# LES SCHWAB TIRE CENTER CONSTRUCTION DOCUMENTS

## 7105 OLD MERIDIAN ROAD FALCON, COLORADO 80831

SITE DEVELOPMENT PLANS

1 SITE PLAN
C100

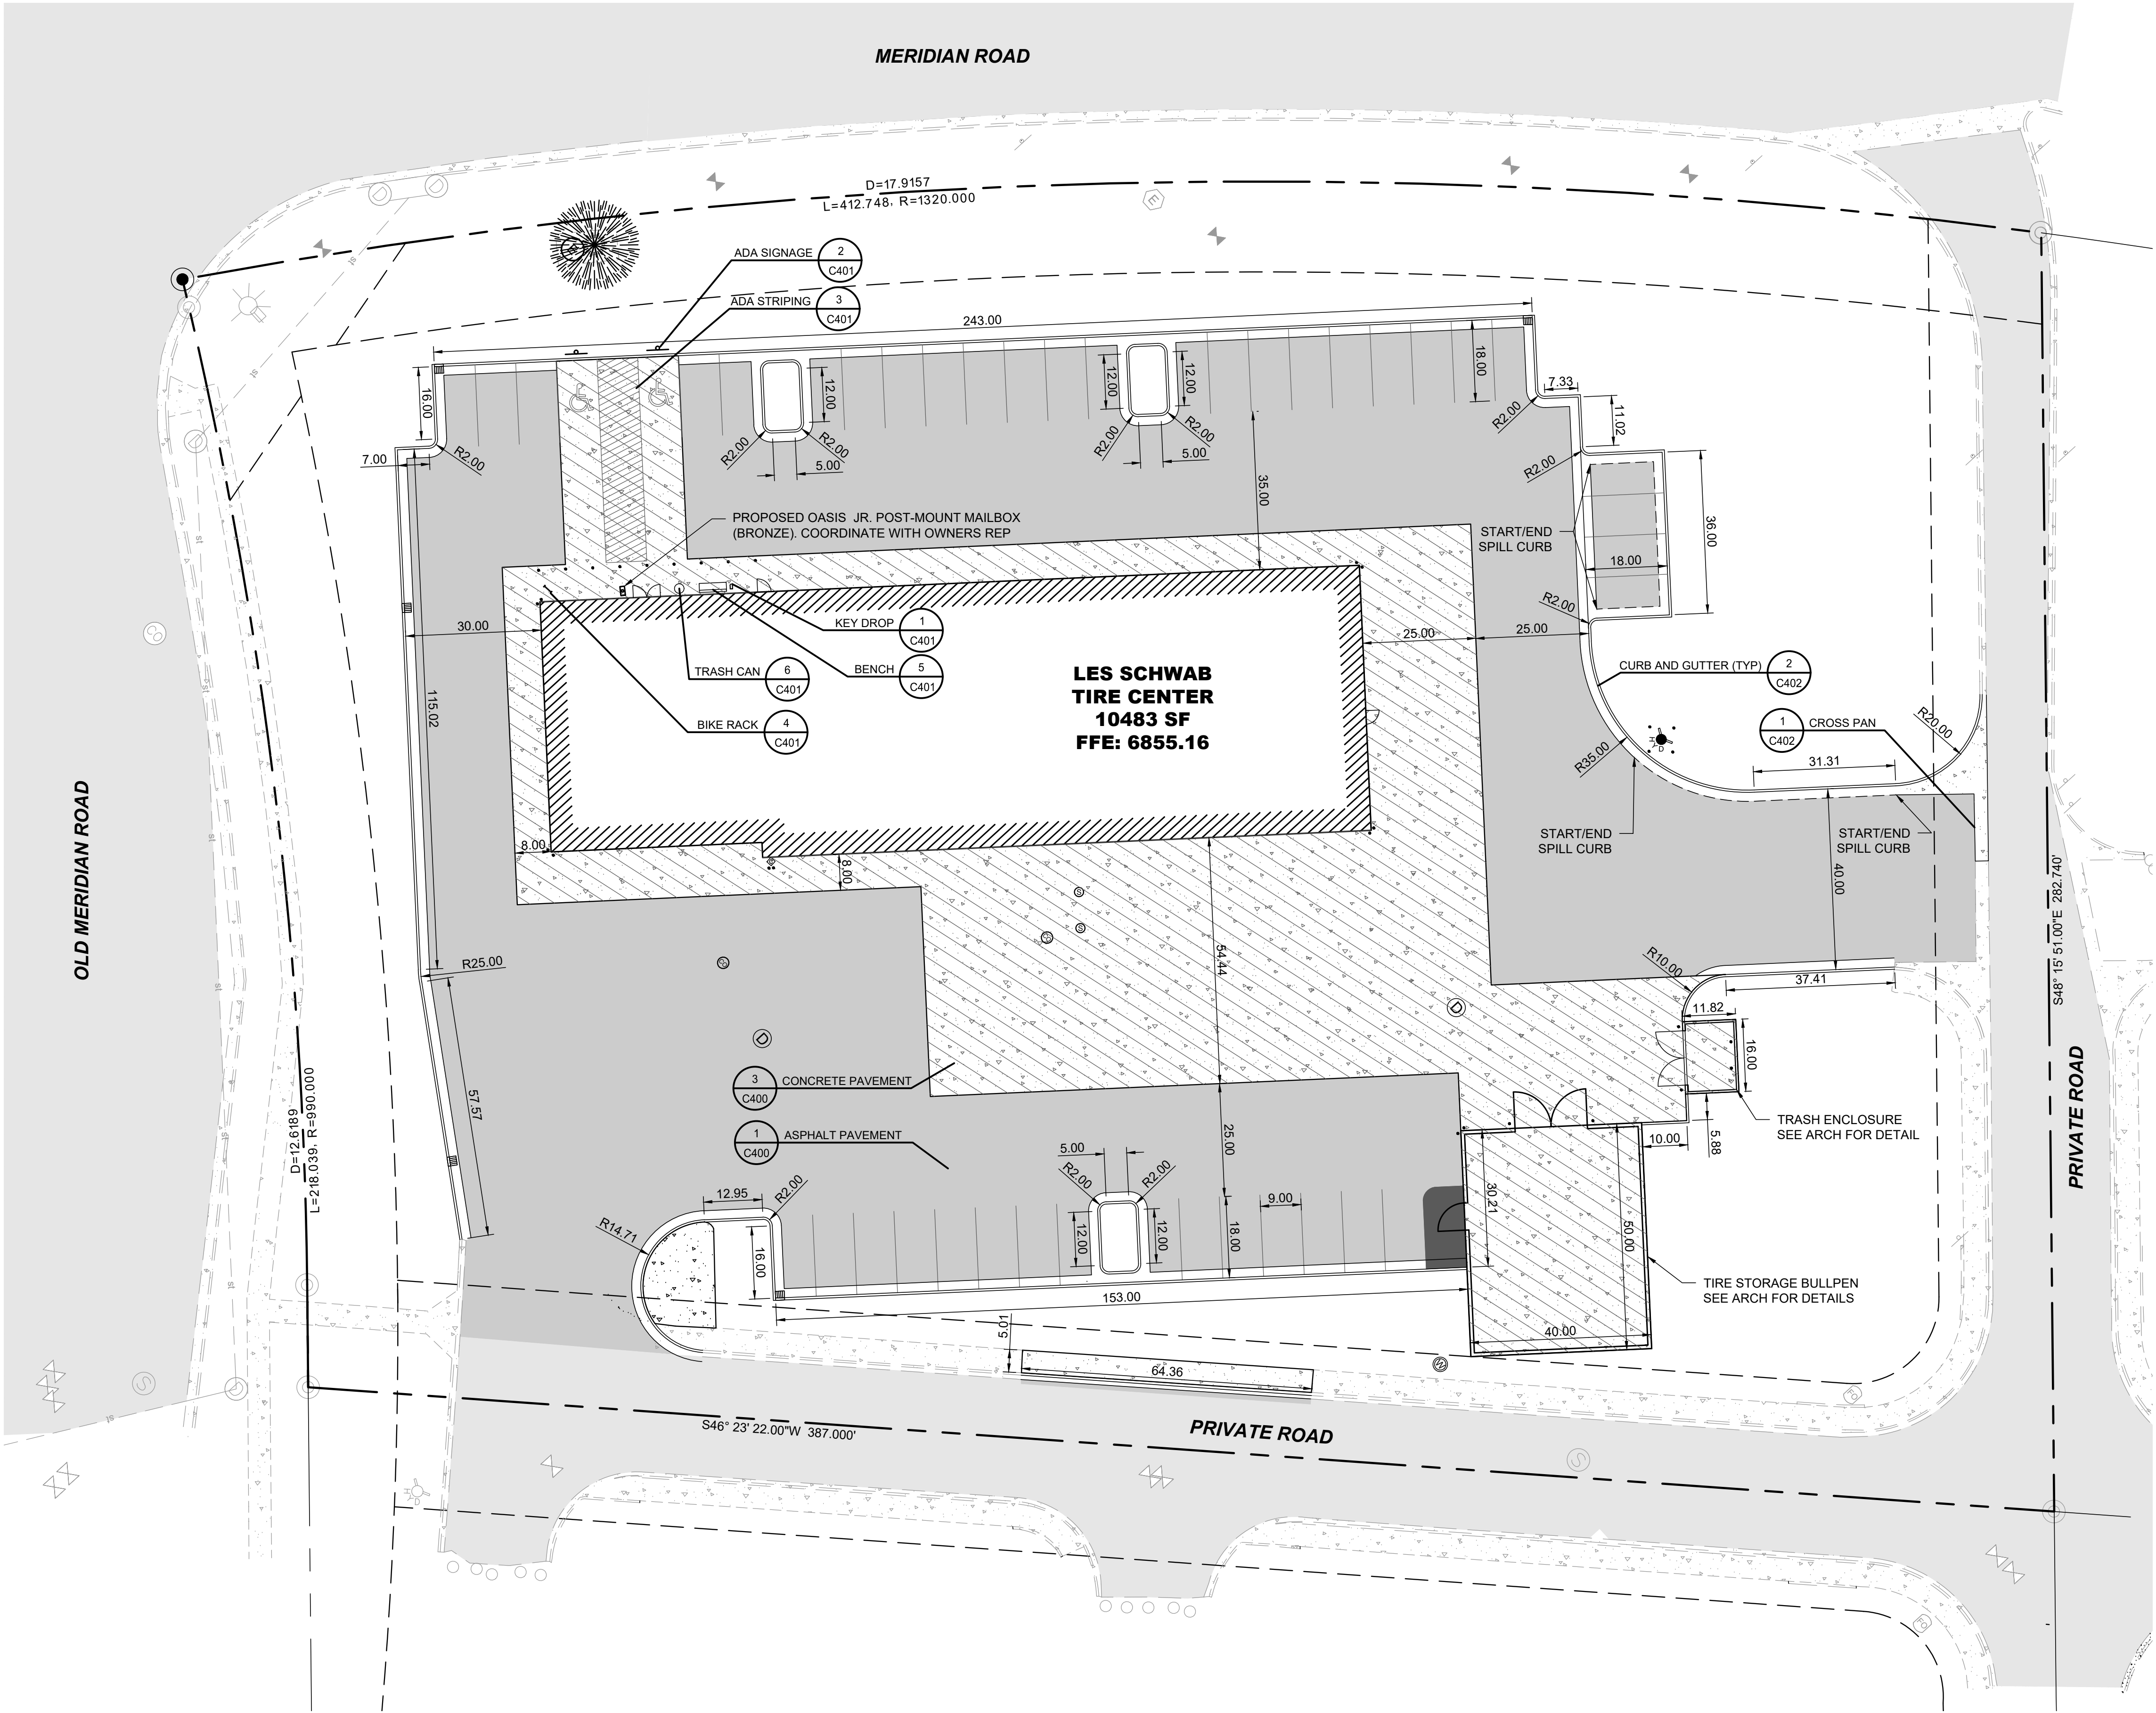
Site Plan does not include any of the required summary information regarding parking standards, lot coverage, etc. Please revise and include all relevant information from Section 5 and 6 of the Land development code regarding

Please provide a site data table. The site data table should include: property address and parcel ID, land use, zoning, lot area, building height, parking (required vs. proposed). Review the dimensional standards included in Chapter 5 and verify all dimensional standards are met.
